From: M MCLOUGHLIN [REDACTED]  
Sent: 27 May 2009 20:26  
To: Planning  
Subject: S6/2009/772/FP

Thankyou for your letter of 7 May re the above planning application, relating to proposed development immediately adjoining our flat at 17 Gloucester Court.

---to flank

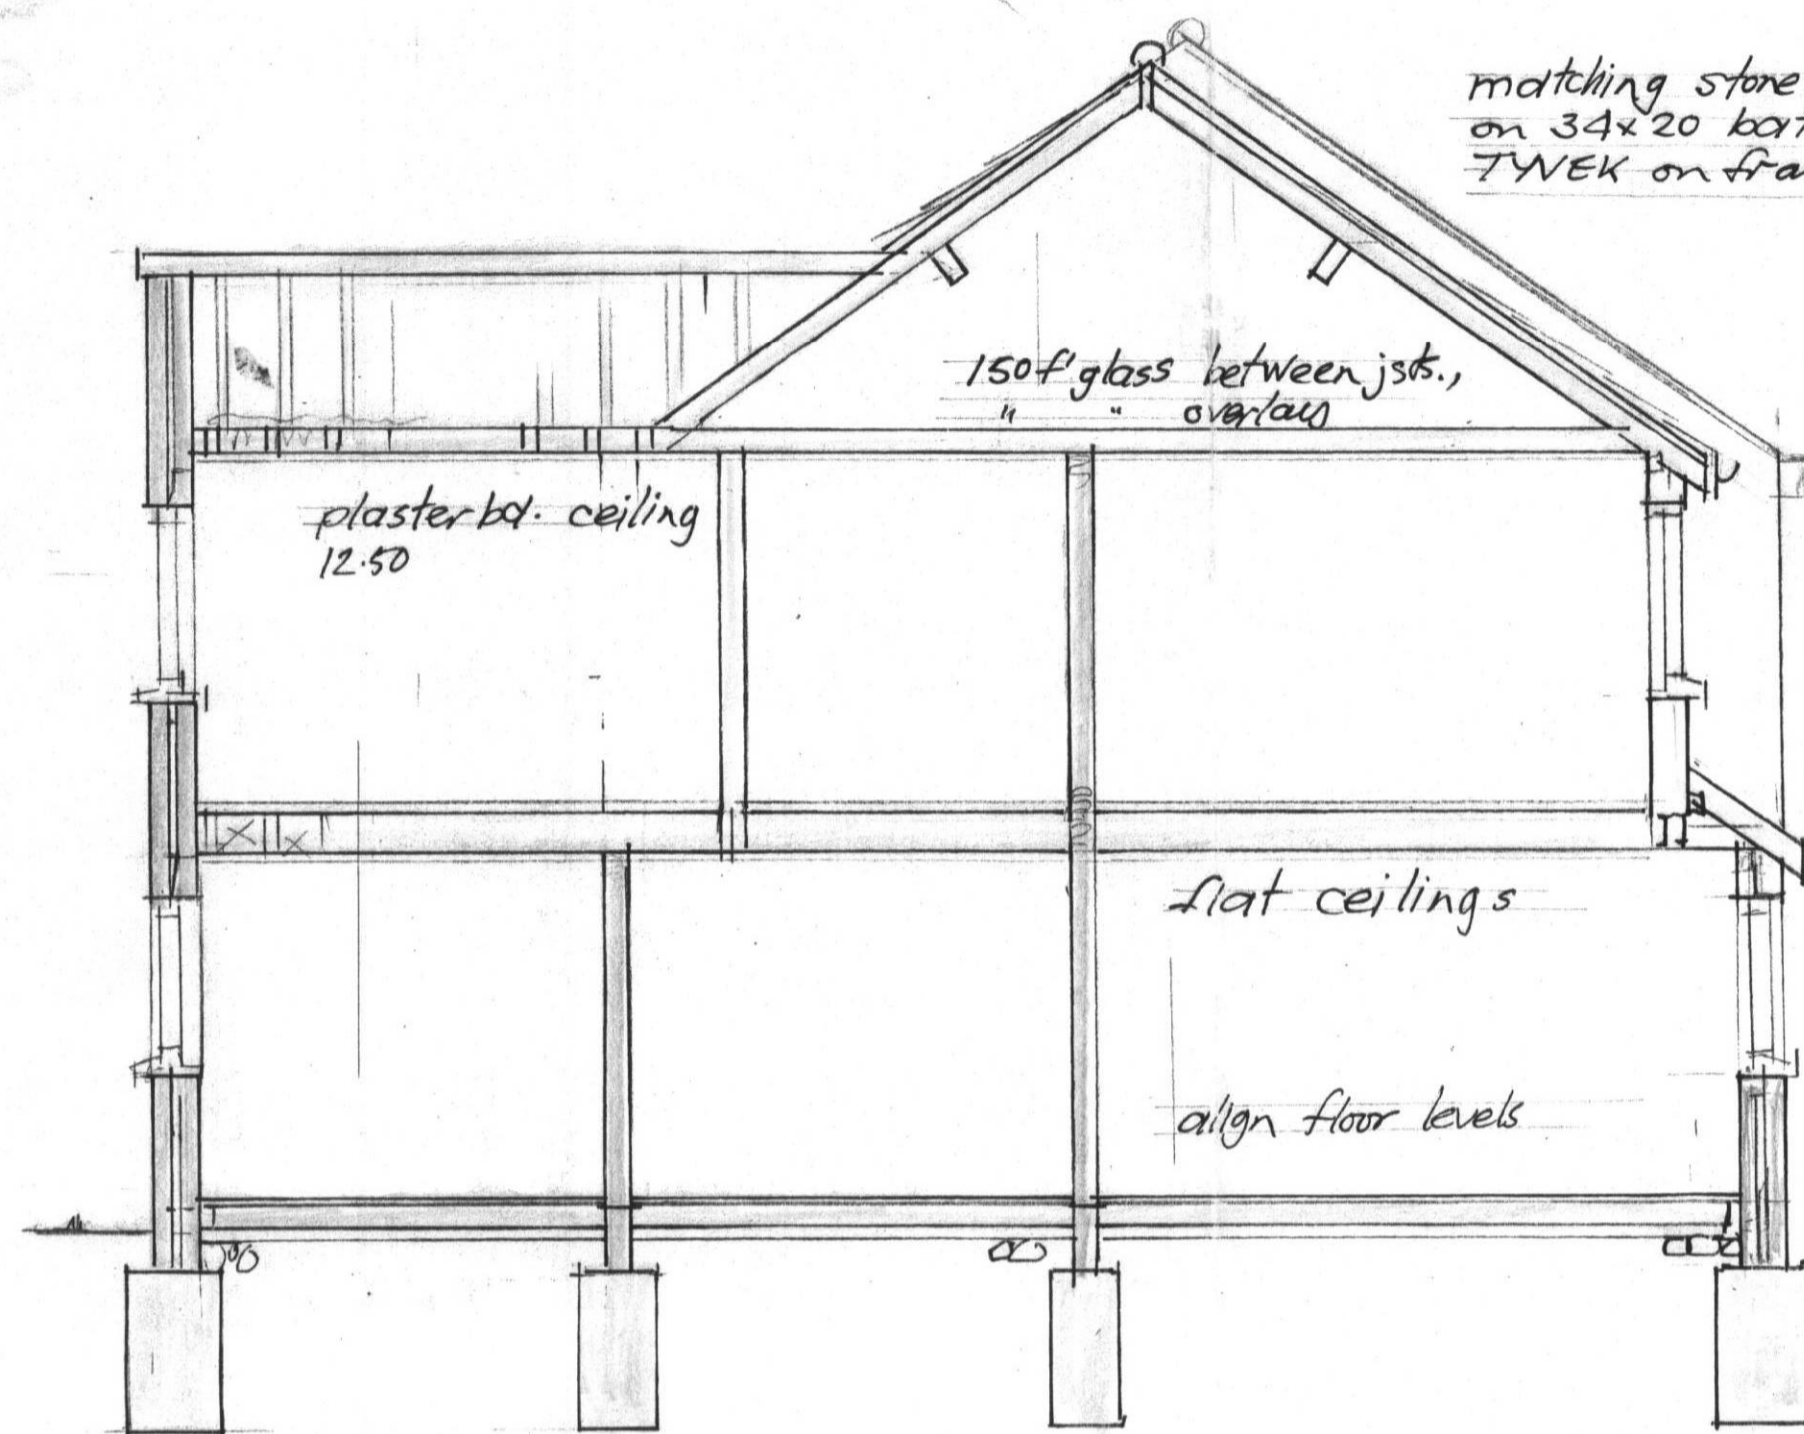
This privacy offered by the arc structure may be compromised by the side extension proposed in the above development. Windows in its side wall would be very close to our flat, and would look in to it. Conversely, we would look into those windows. From our point of view and that of our three neighbours in this block, it would be better if there were no windows in that side wall. If such a window is essential, could it be at the road end?
